Memorandum

To:	Planning	From:	Environmental Health
Officer:	Claire booth	Officer:	Neil Martin
Reference:	3/2012/0298	Extension No:	3214
Date:	21st May 2012

Planning Application: 3/2012/0298
Location: 59 Woone Lane Clitheroe, Lancashire, BB7 1BG
Development: Installation of flue for proposed Chinese take away.

59 WOONE LANE ~ CLITHEROE
PROPOSED SIDE & REAR ELEVATIONS

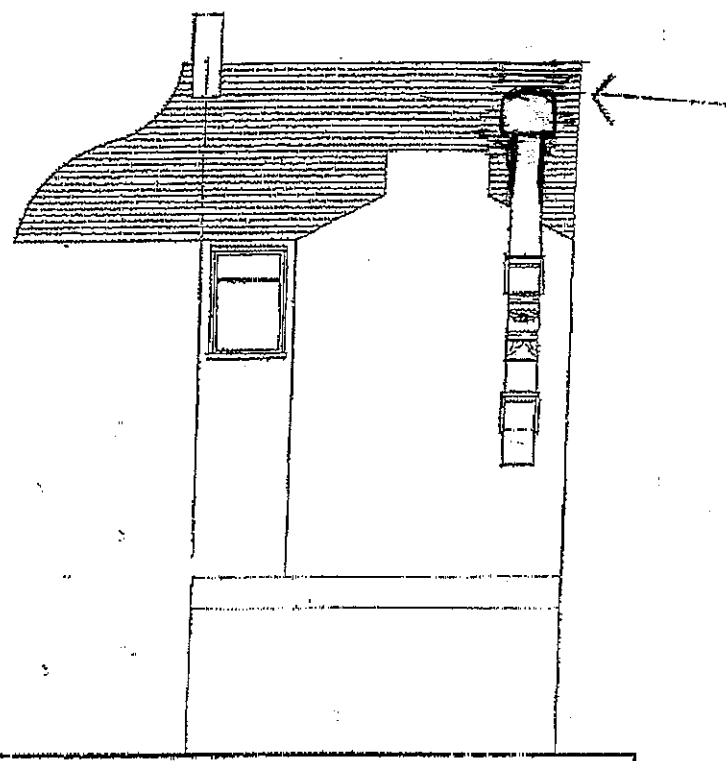
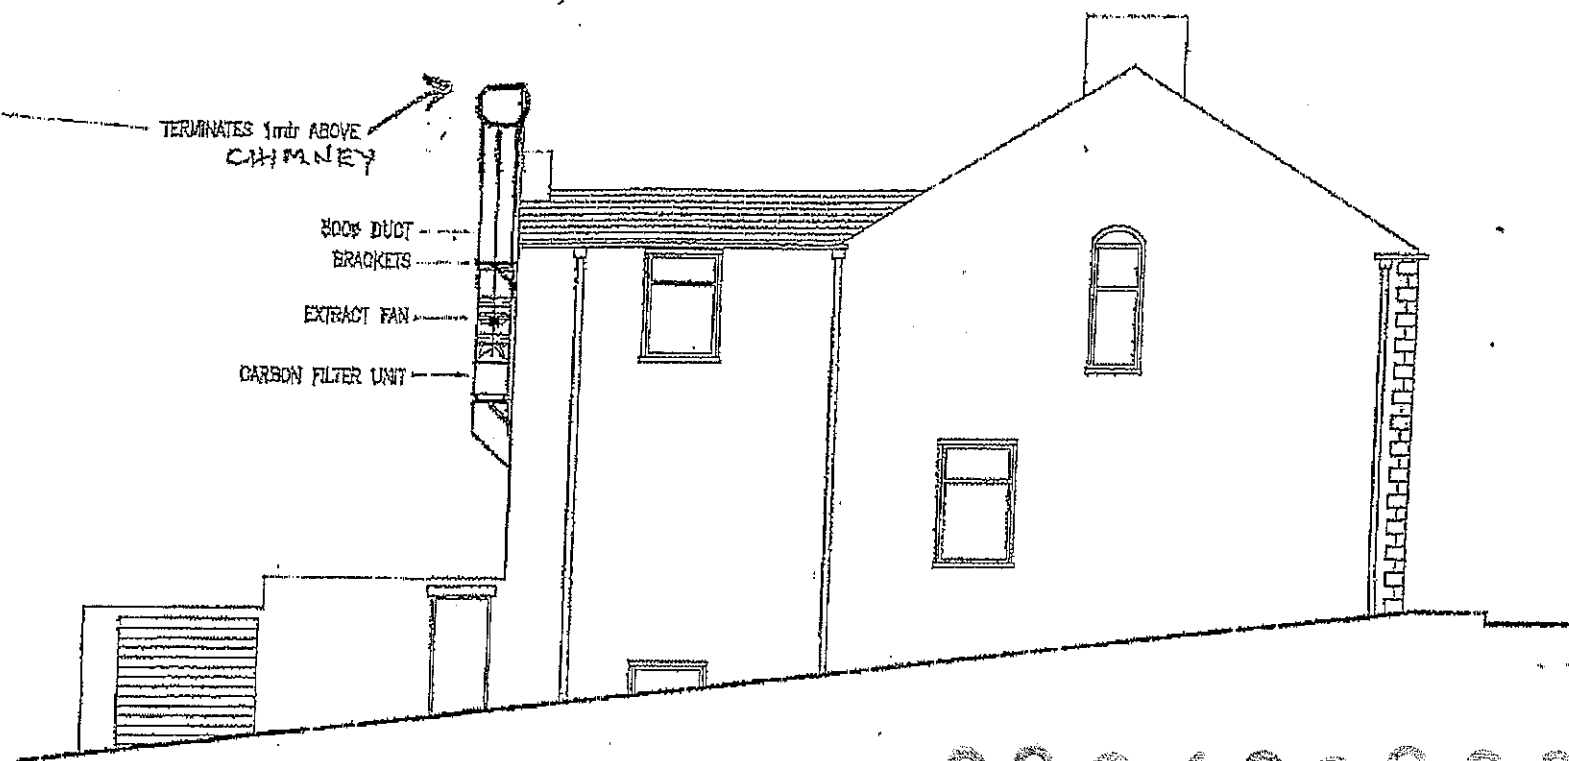
The proposed termination of the flue is not sufficient to ensure suitable dispersion of the exhaust gases. The flue must terminate at a minimum height of 1m above the roof ridge of the property and must not be fitted with any restriction to the final opening.

"The flue shall terminate at least 1 m above the roof ridge of the property and shall not be fitted with any restrictions"

Proposed Rear Elevation

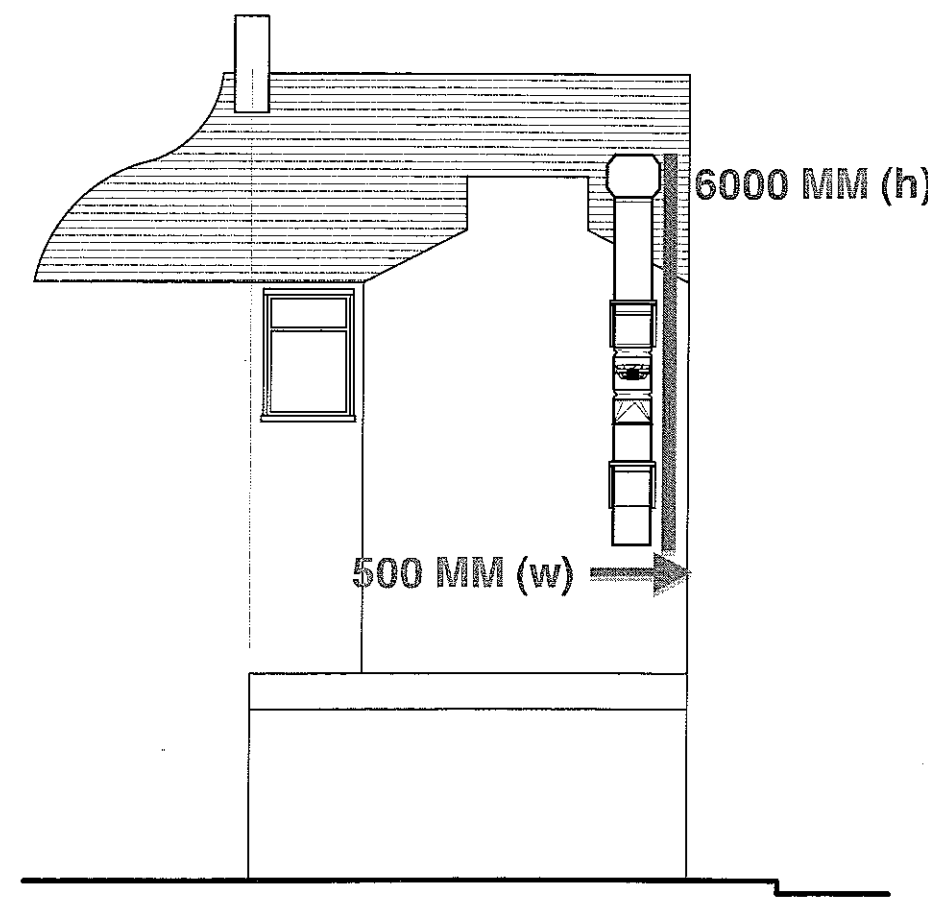
To prevent any potential noise from being emitted from the structure the applicant has suggested the use of a silencer. In addition to this methods of installation should be used to ensure that noise and vibration are not transmitted through the structure to neighbouring properties.

"Details of the fixings to be used shall be provided to and agreed by the local planning authority prior to commencement of any installation works."
